9 December 2025

**Re: New Rouse Hill Hospital Development
SSD-96248991
GPT Submission**

We are writing to Department of Planning, Housing & Infrastructure (DPHI), as an adjoining landowner, to provide our comments and general support of the above-mentioned State Significant Development Application (SSD-96248991).

**DRAWING TITLE**  
 SSDA - SITE PLAN PROPOSED

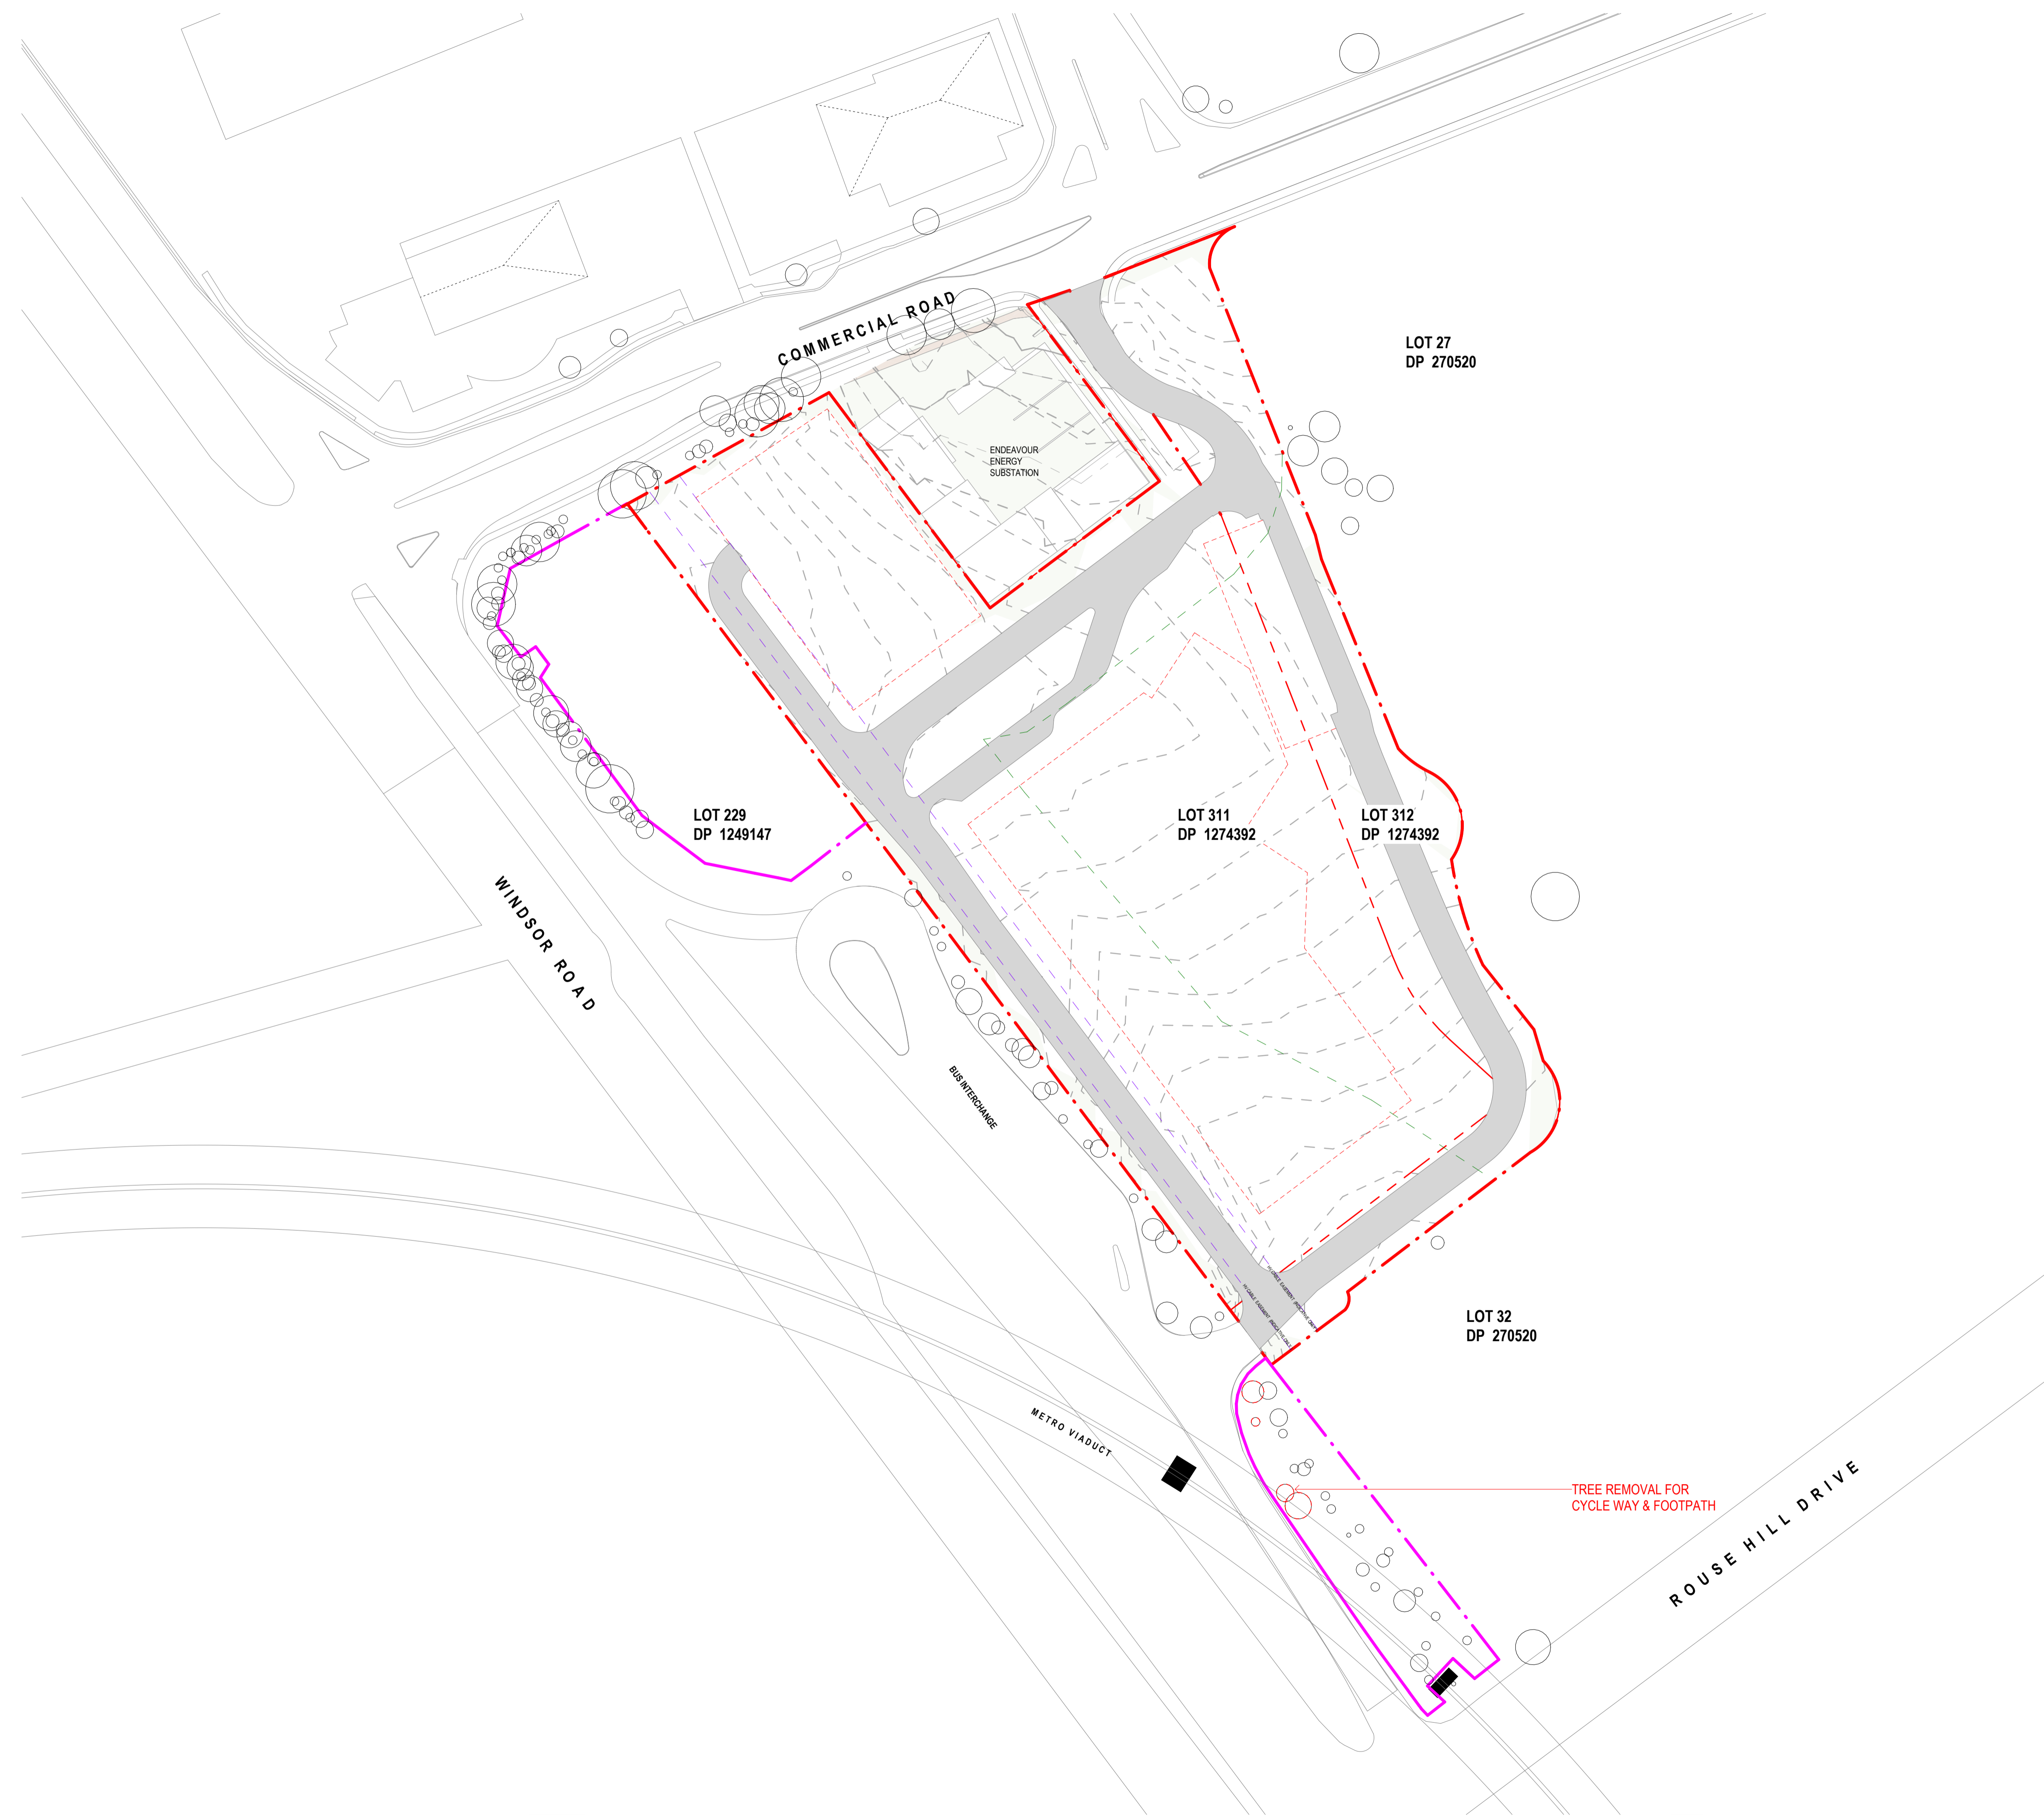
The proposed road network to facilitate the operations of the future Rouse Hill Hospital does not currently allow for vehicular access between Hospital Road and Park Road North (Rouse Hill Northern Frame). GPT are supportive of their being a logical road connection between the two sites, to achieve a more efficient traffic flow and provide alternate routes during peak periods of the day. Given the existing satisfactory performance of the Windsor Road/Commercial Rd/Rouse Hill Drive/Caddies Blvd intersections, and additional traffic impacts of the RHH, further consultation should be undertaken between key stakeholders (i.e. GPT, TfNSW, HINSW and Council) to determine the best traffic management approach for this precinct.

Figure 16 | Landscape Masterplan (Source: EIS)

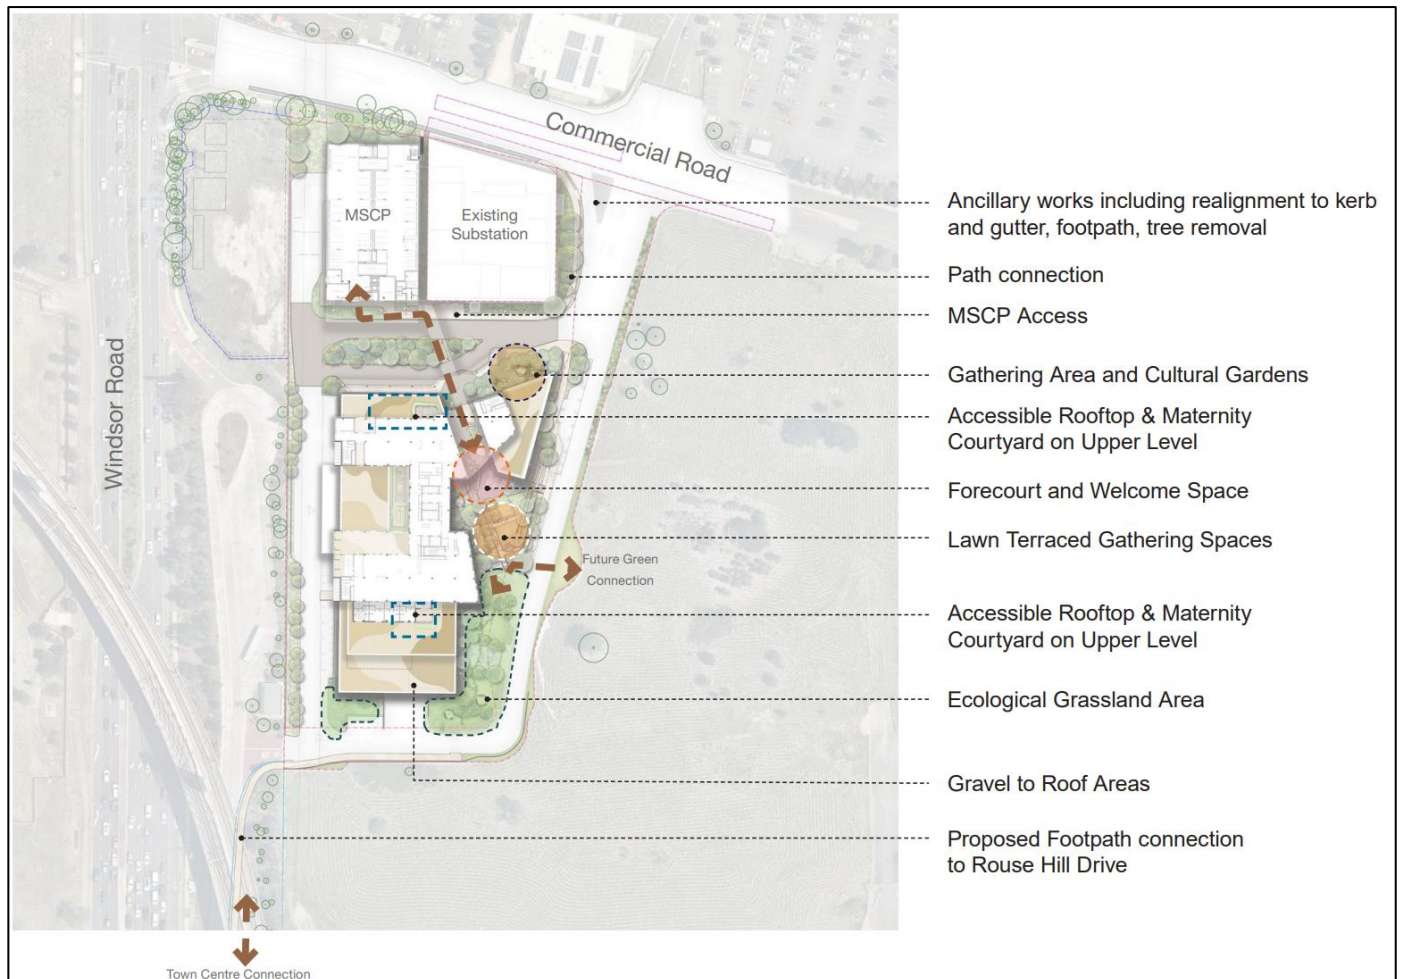
Design and delivery of the external ground landscaped areas should be further considered and coordinated with GPT as the direct neighbour of the RHH site. The Site Image landscape design does not take into account the adjacent proposed footpaths adjoining the Northern Frame's western boundary and Commercial Road, nor the proposed public Central Park.
